***Planning Department
Transportation Development Services***

August 27, 2015

**Re: Assisted Living Center
1331 Cuesta Abajo Ct., NE
Certificate of Occupancy – Transportation Development
Engineer's/Architect's Stamp dated 6-21-15 (D16-D101)
Certification dated 8-19-15**

Enlarged Site Plan

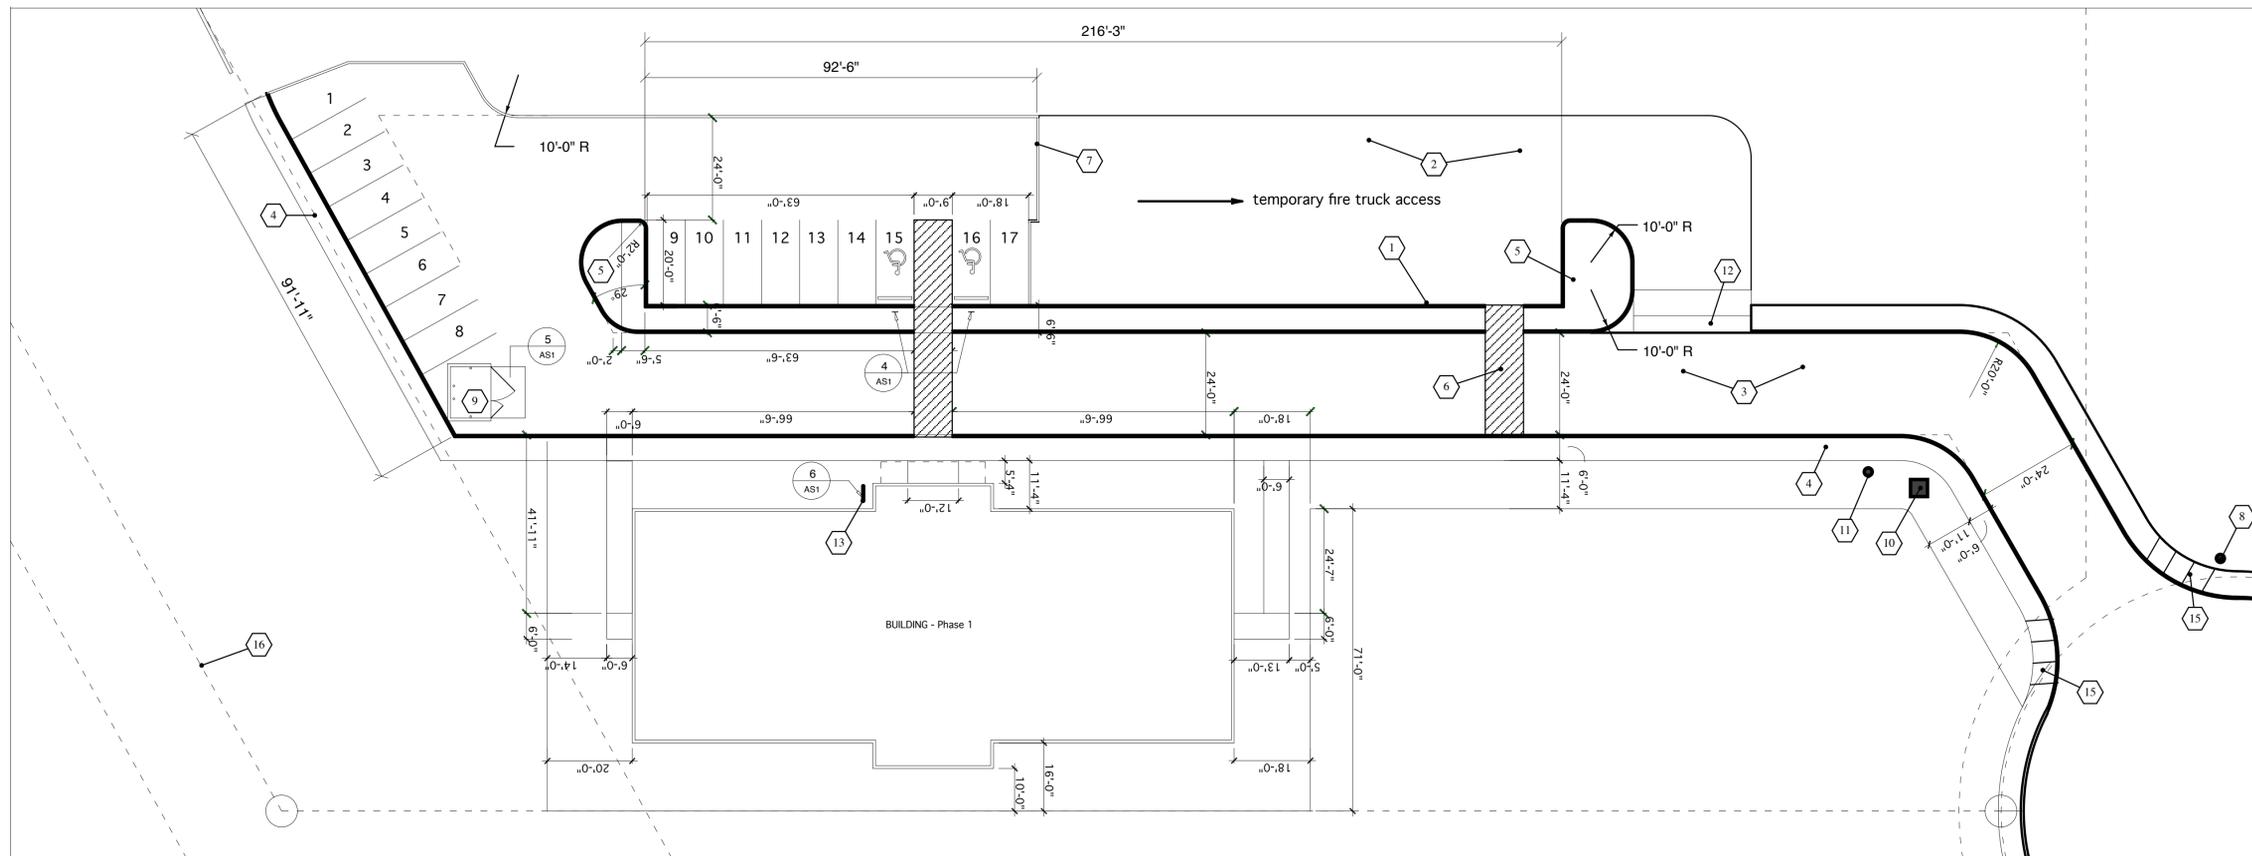
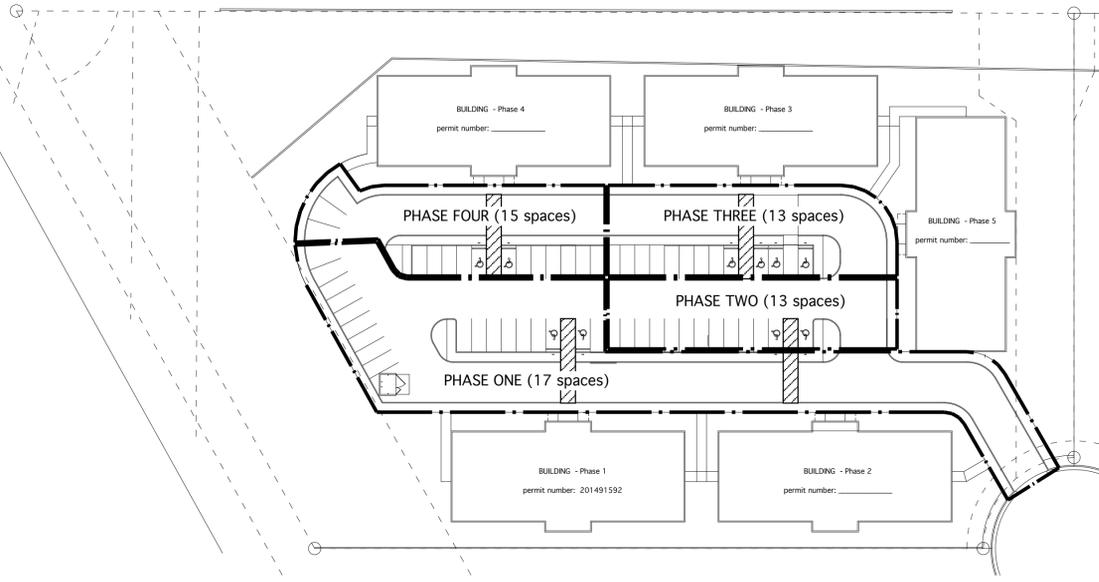
1. Please identify all doors, structures, sidewalks, curbs, drive pads, walls and anything that influences the parking and circulation on the site.
2. Please provide more detail on grades and slopes in the parking area and/ or the handicap accessible parking areas and the ADA pedestrian walk way.

3. Please provide a Legend showing line types.
4. The ADA van accessible sign must have the required language per 66-7-352.4C NMSA 1978 **"Violators Are Subject to a Fine and/or Towing."**

5. The ADA access aisle shall have the words **"NO PARKING"** in capital letters, each of which shall be at least one foot high and at least two inches wide, placed at the rear of the parking space so as to be close to where an adjacent vehicle's rear tire would be placed. (66-1-4.1.B NMSA 1978)

6. Show all drive aisle widths and radii. Per Fire Department, the turning radii for emergency vehicles must be a minimal of 28 Ft. It appears that the radius at the north end of the parking lot and the radii at the south drive pad entrance do not meet the Fire Department requirements. Please provide details of drive path turn around and south drive pad entrance, listing all radii.

7. For passenger vehicles, the minimum end island radius is 15 feet. Landscape island radius for delivery trucks is 25 feet or larger. Please label all radii.

8. A five-foot keyway is required for dead-end parking aisles. The north end of the parking lot at space labeled No. "1" will require a 5 Ft. turn out, so that vehicles may have adequate room to back out and exit.

9. Please specify the City Standard Drawing Numbers when applicable.
10. Provide a min 6" or max 8" high concrete barrier curb or other acceptable barrier between landscaping and parking areas and/or drive aisles. Please identify curb barriers.
11. Please include two copies of the traffic circulation layout at the next submittal. Please also include Sheet No. 2 with missing details on bicycle parking, curb barriers, side walk and ADA signage.
